# OXFORDSHIRE COUNTY COUNCIL'S RESPONSE TO CONSULTATION ON THE FOLLOWING DEVELOPMENT PROPOSAL

**Application no:** 22/01340/OUT

**Proposal:** Application for outline planning permission (all matters reserved except means of access (not internal roads) from b4100) for the erection of buildings comprising logistics (use class b8) and ancillary offices (use class e(g)(i)) floorspace; energy centre, hgv parking, construction of new site access from the b4100; creation of internal roads and access routes; hard and soft landscaping; the construction of parking and servicing areas; substations and other associated infrastructure.

**Location:** East Of Baynards Green Farm Street To Horwell Farm Baynards Green

CATCHMENT 1 PROPOSED LINKED ATTENUATION / SOAKAWAY BASINS

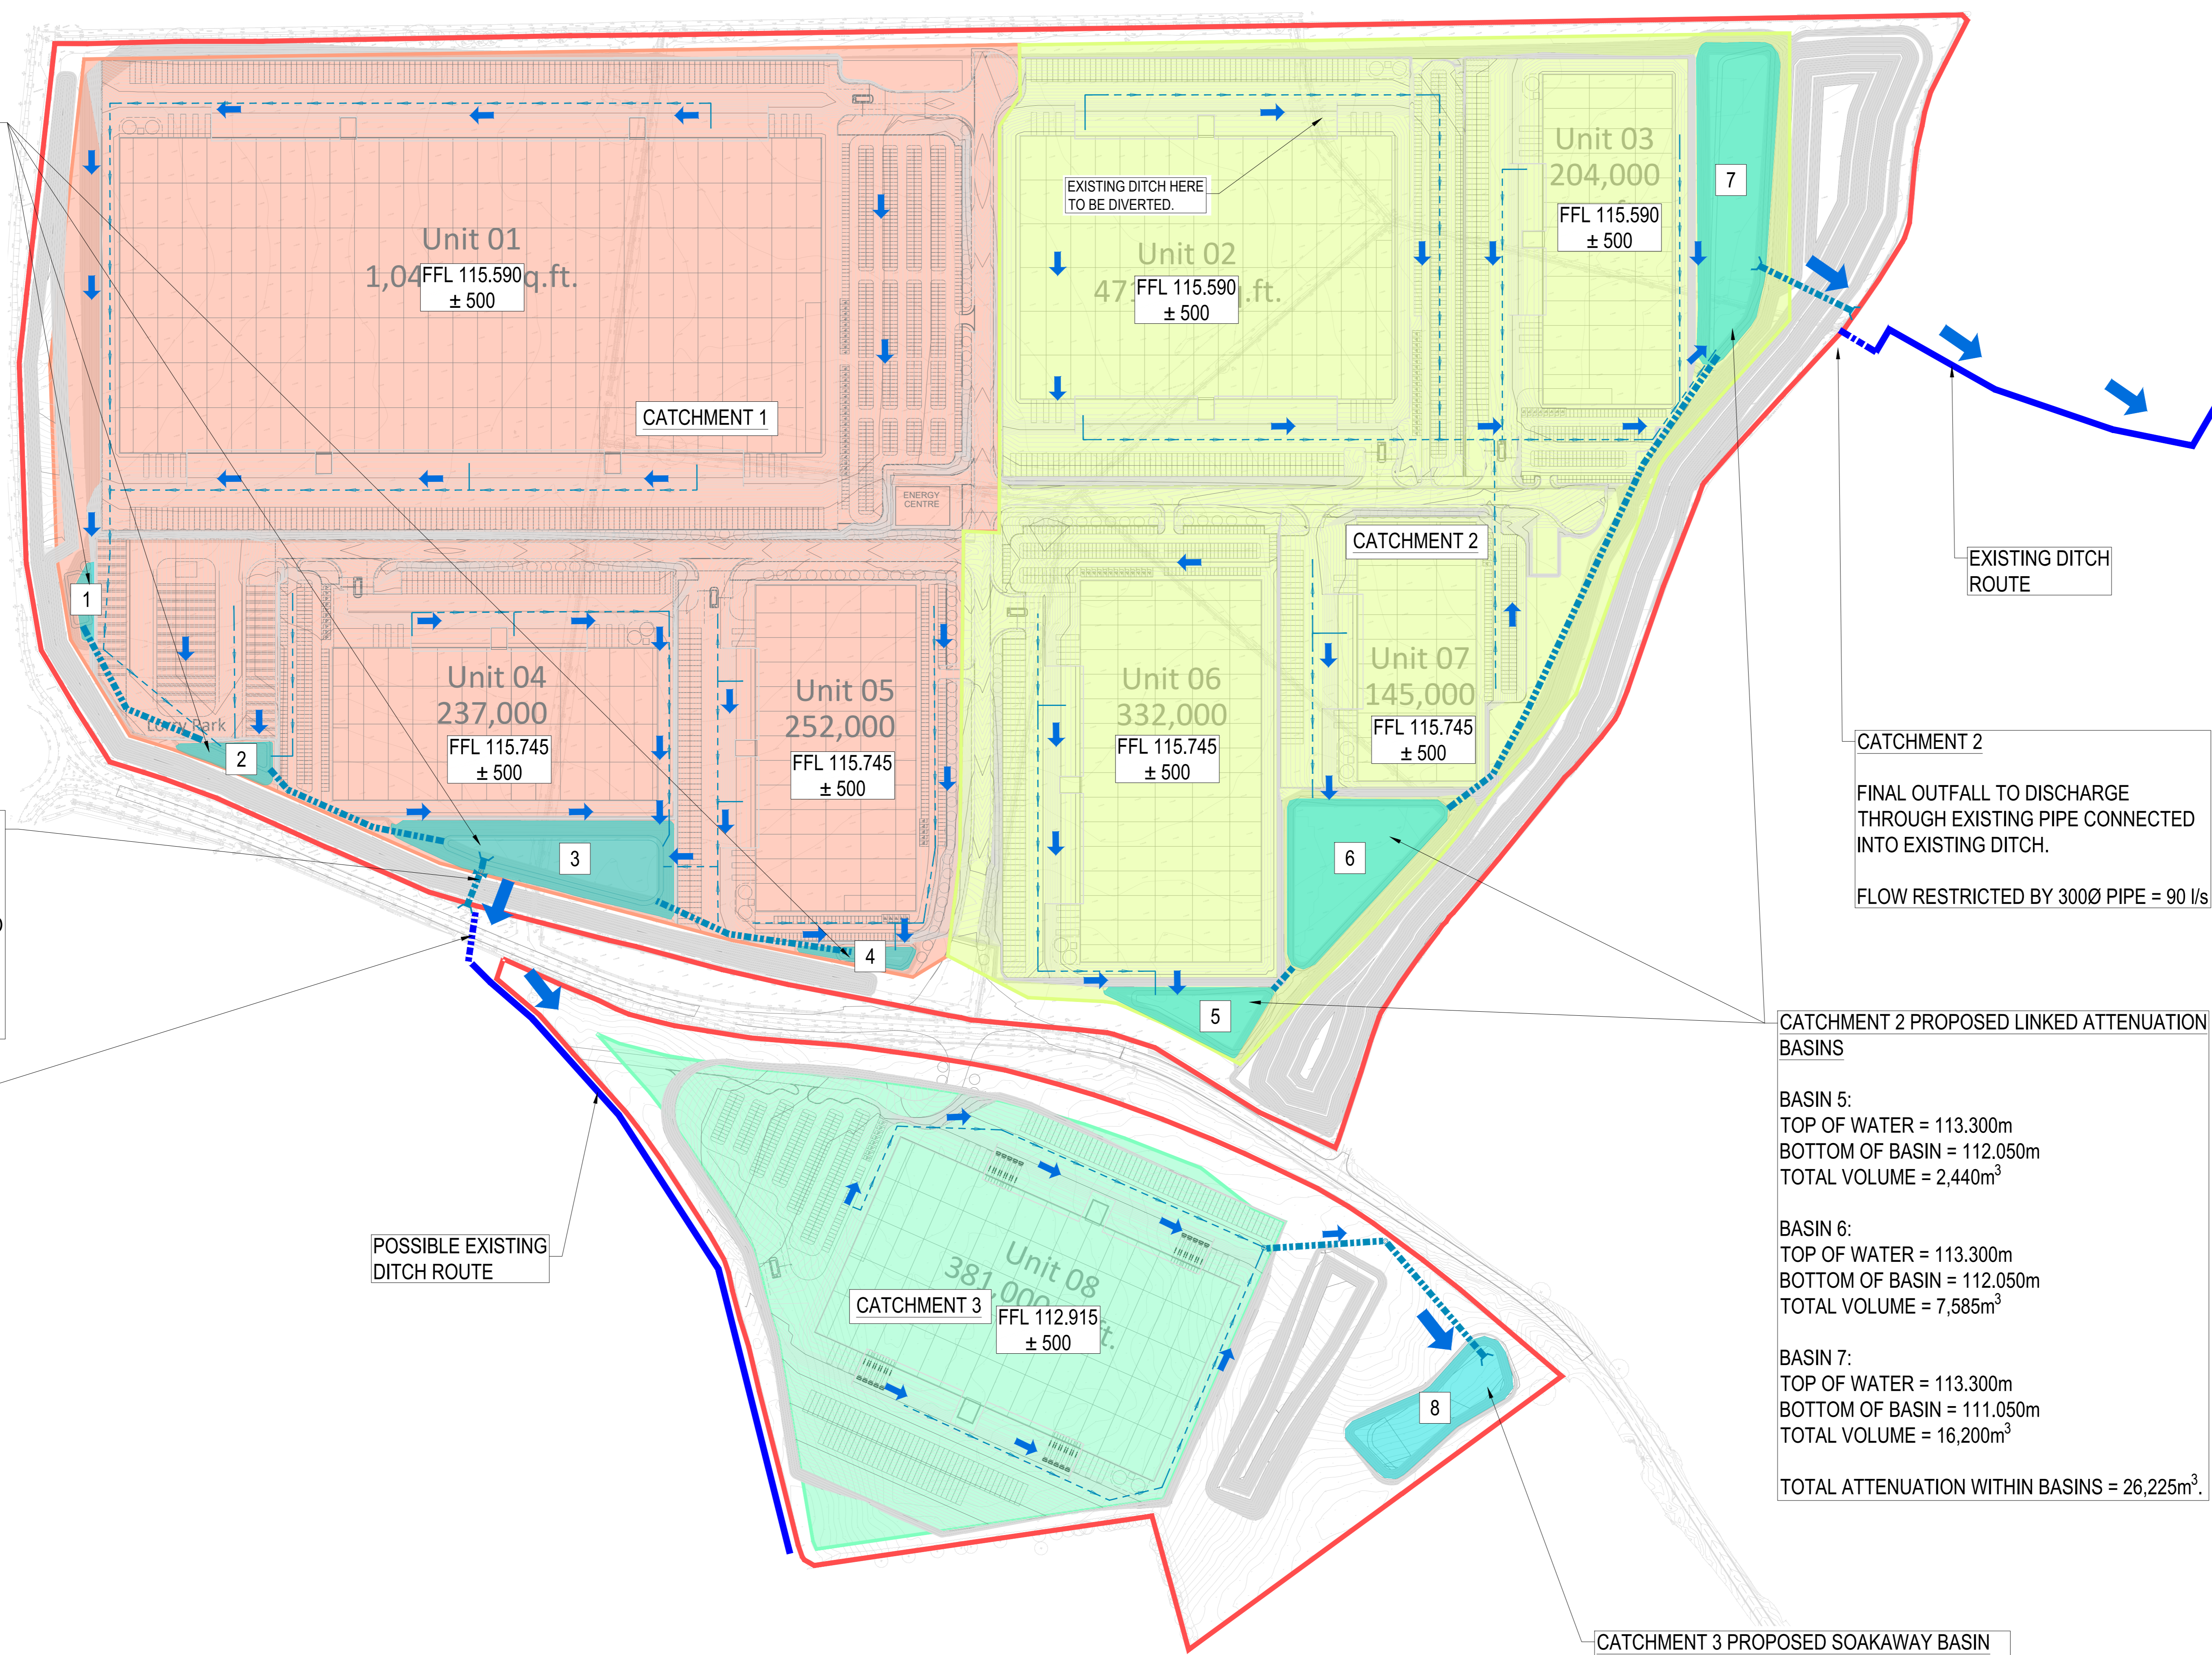
Provide surface water catchment plans clearly showing the extent of the areas and stating the area.

Provide attenuation volumes and discharge rates on the drainage strategy plans.

Clearly identify infiltration systems on the drainage strategy plans.

Overall site boundary not shown on the drainage plans.
